Directorate for Economic Growth and
Regeneration
PO Box 4
Town Hall
Lancaster
LA1 1QR

Your ref: 3/2025/0318
Our ref: 3/2025/0318/HDC/KW
Date: 27 May 2025

Location: The Old Garage Site Newton Road Dunsop Bridge BB7 3BB
Proposal: Approval of details reserved by conditions 3 (materials), 4 (location of existing water mains and sewers), 5 (drainage scheme), 6 (construction traffic management plan), 9 (cycle storage), 10 (surface water drainage car park), 11 (delivery and servicing plan), 13 (bird and bat boxes) and 14 (electric vehicle charging points) on planning permission 3/2023/0816.
Grid Ref: 366038 450100

Dunsop Bridge Old Garage Draft Traffic Management Plan

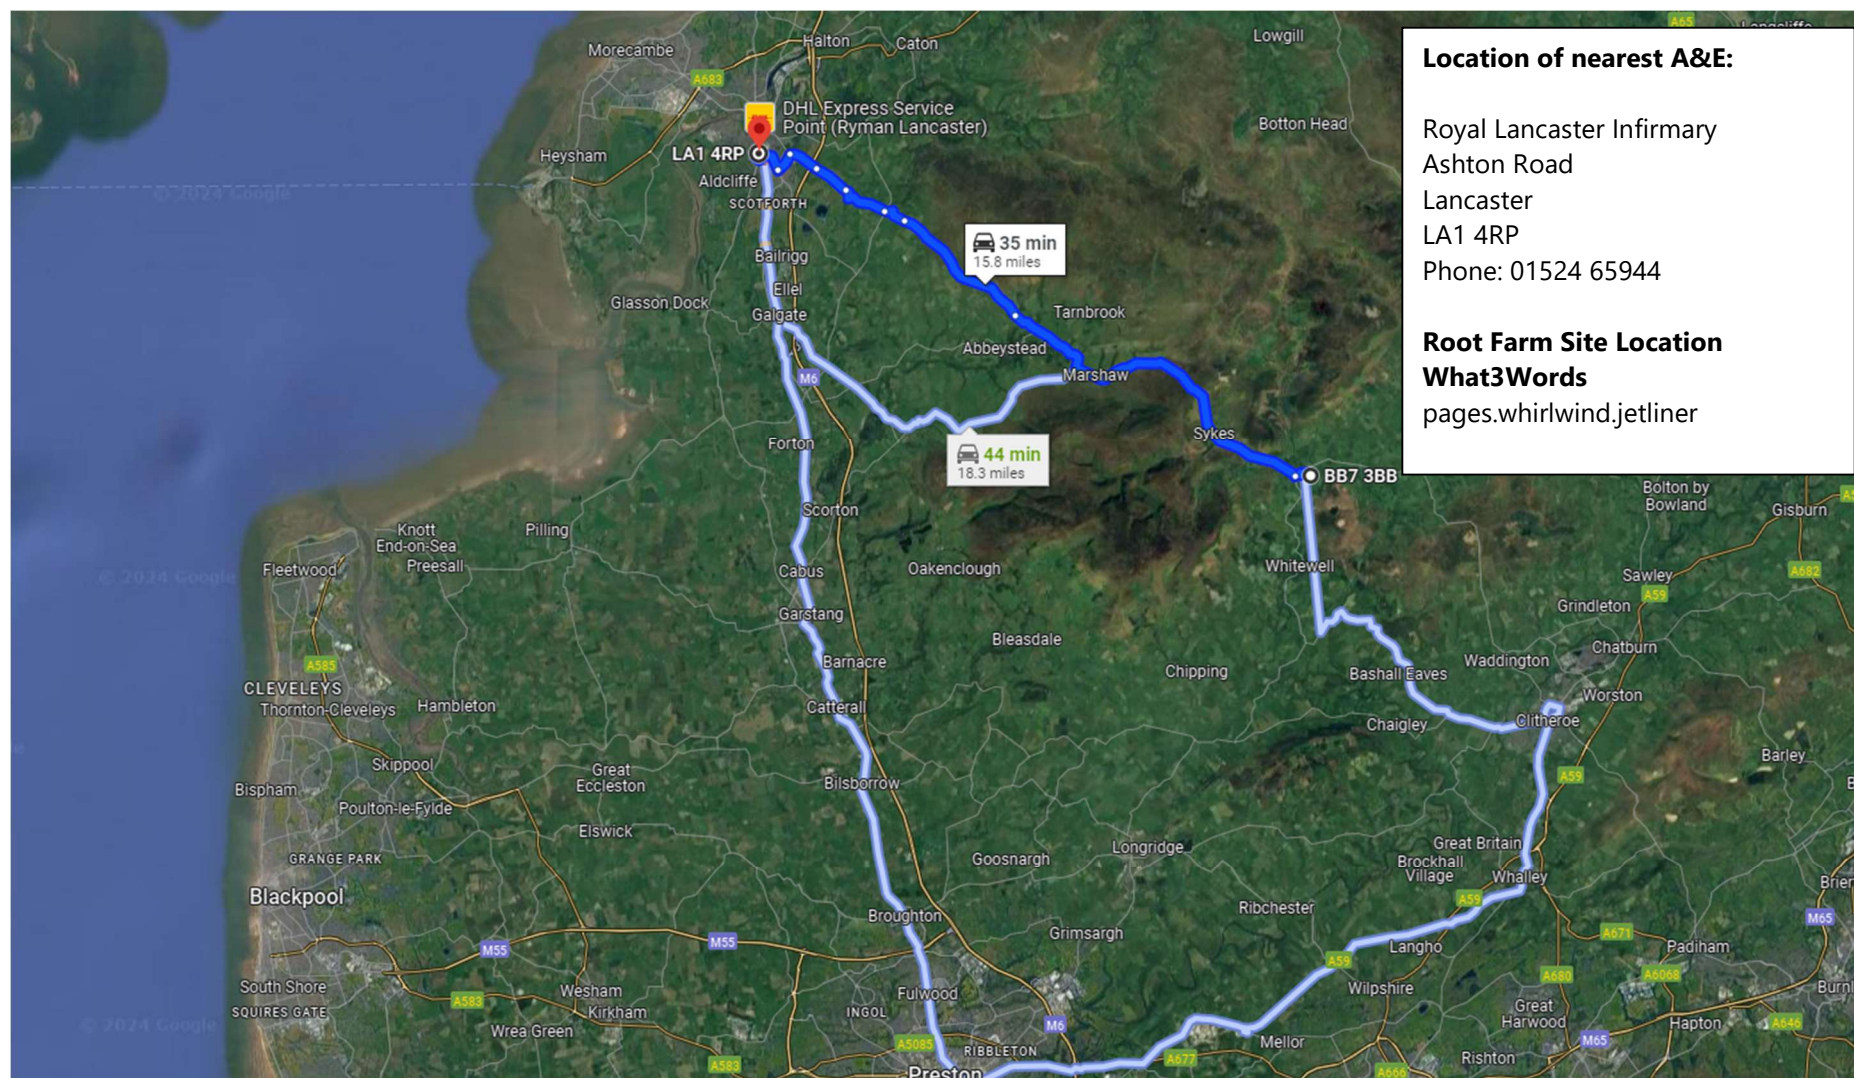
The LHA have reviewed Construction Health and Safety Plan and note that a site traffic management plan has been provided which shows the direction of vehicles coming in and from the site. It is noted that routing information will be shared with all suppliers/sub-contractors advising of the most appropriate direction to approach site and no deliveries will be made on articulated vehicles. Wheel washing and dust control measures will be undertaken to prevent debris from being transported on to the adopted highway. The Construction Traffic Management plan shows parking and turning areas as well as a onsite materials and equipment storage within the site boundary. The LHA is satisfied with the information provided and have no objection to the discharge of condition 6.

Drawn	PB	Chkd		Date	Oct 2024	Scale	var
Sheet Size	A1	Drawing No.	23120-DR-C-0120	Revision			P4

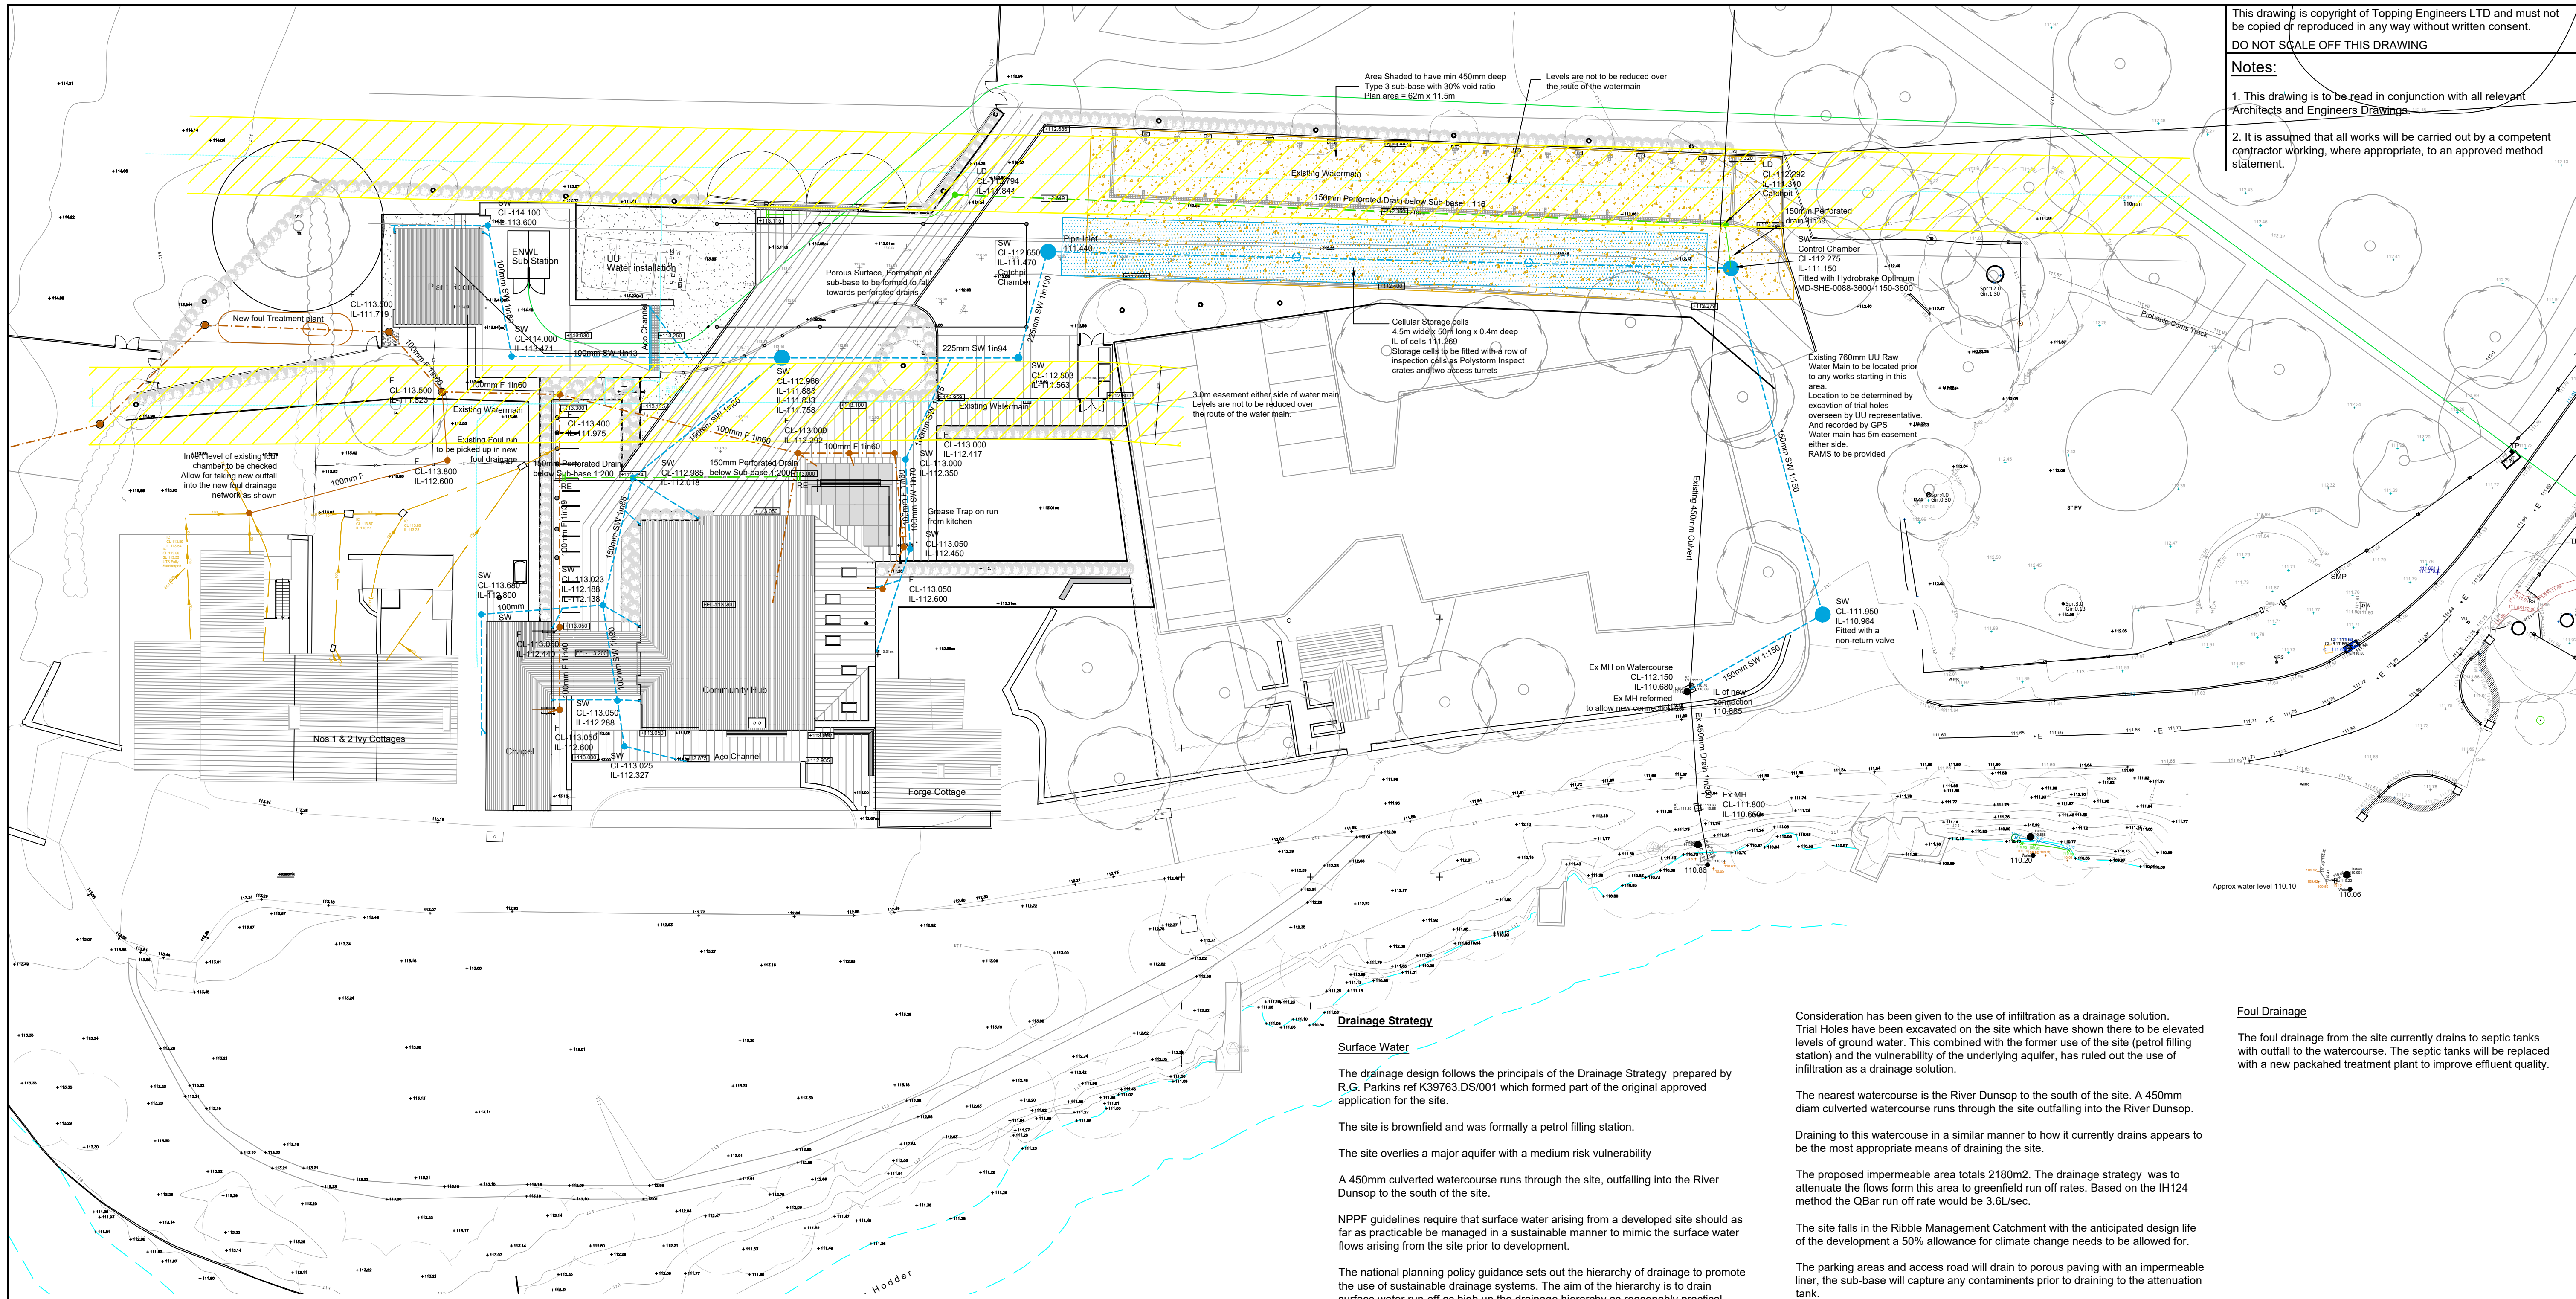
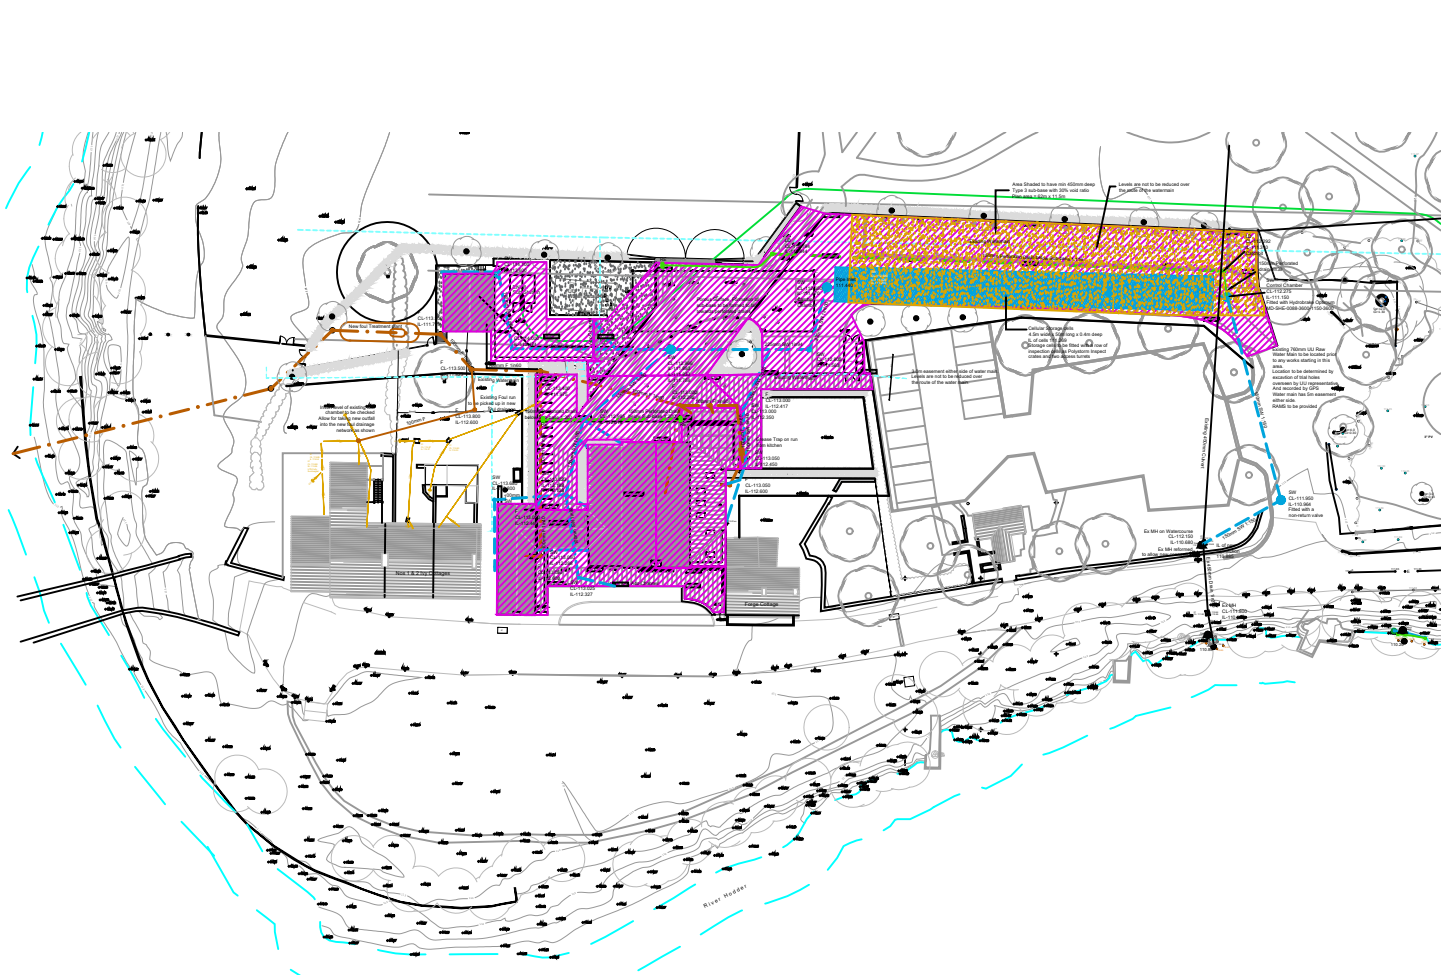
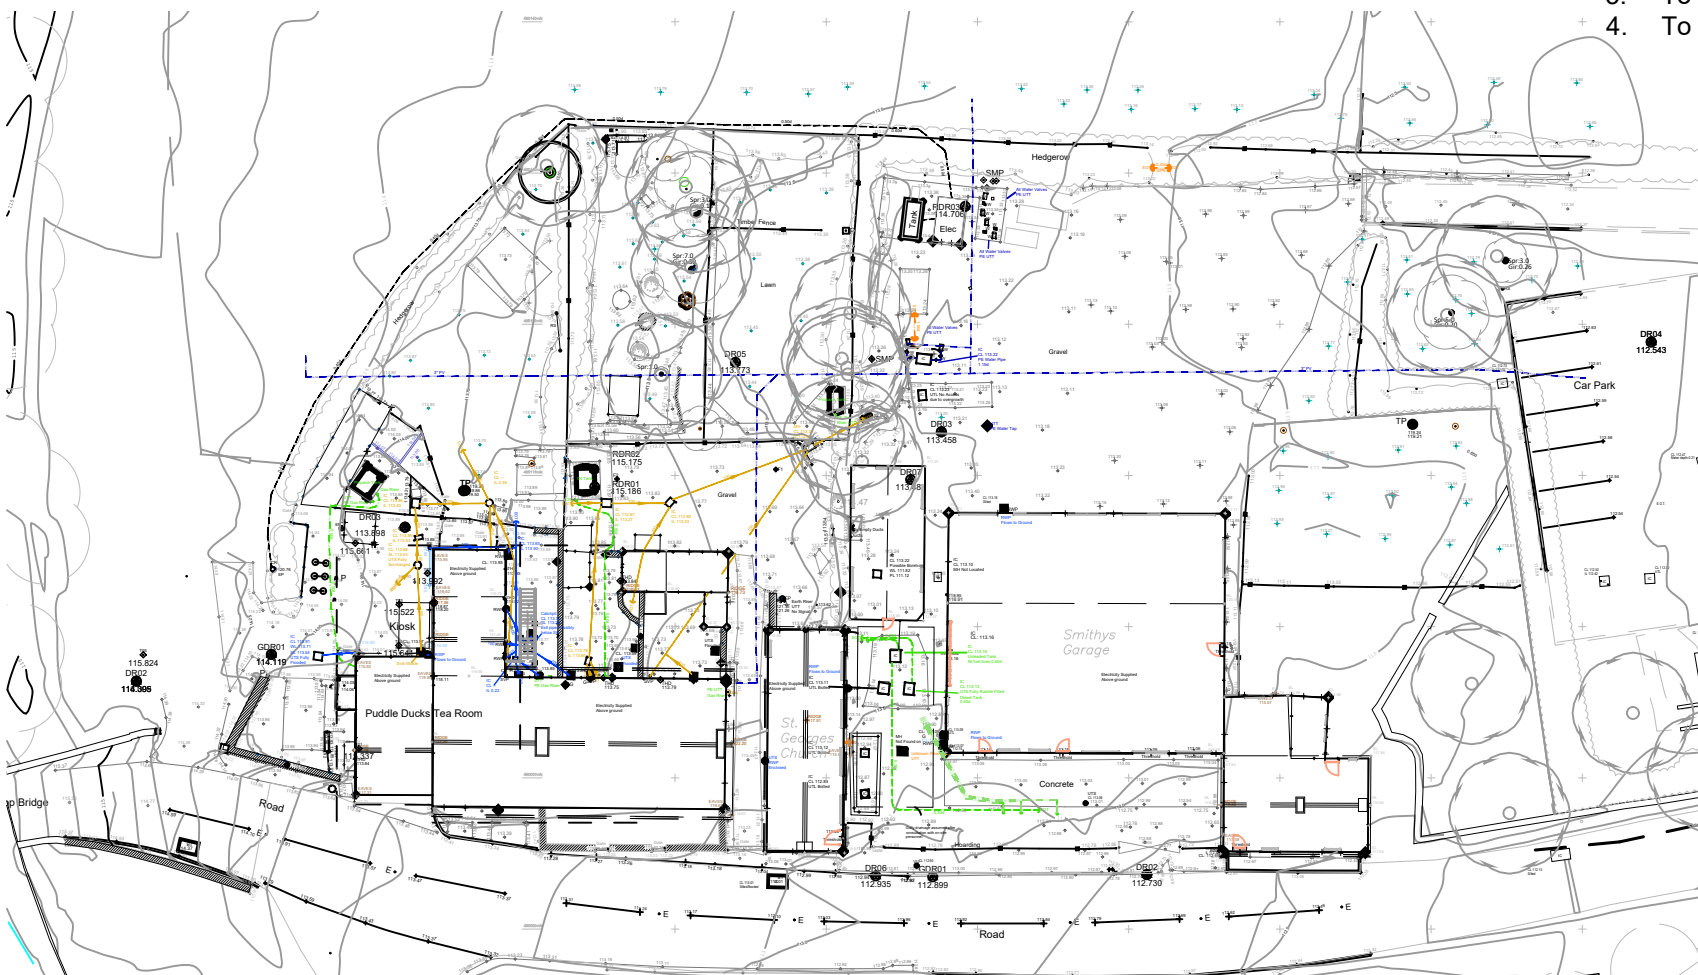
The LHA has reviewed the Drainage Proposals, drawing 23120-DR-C-0120, P4, and acknowledges the drainage strategy for the site. This strategy is acceptable to the LHA, providing that the Local Planning Authority is also satisfied with the proposal. For drainage strategies which are connecting to a watercourse, the Applicant needs to be aware that under the Land Drainage Act 1991 consent is required from the Lead Local Flood Authority for work which may alter or impede the flow of water, regardless of whether the watercourse is culverted or not. Consent must be obtained before works are started on site as it cannot be issued retrospectively. Developers should contact the Flood Risk Management Team at Lancashire County Council to obtain Ordinary Watercourse Consent. Information on the application process and relevant forms can be found here: <https://www.lancashire.gov.uk/flooding/drains-and-sewers/alterations-to-a-watercourse>
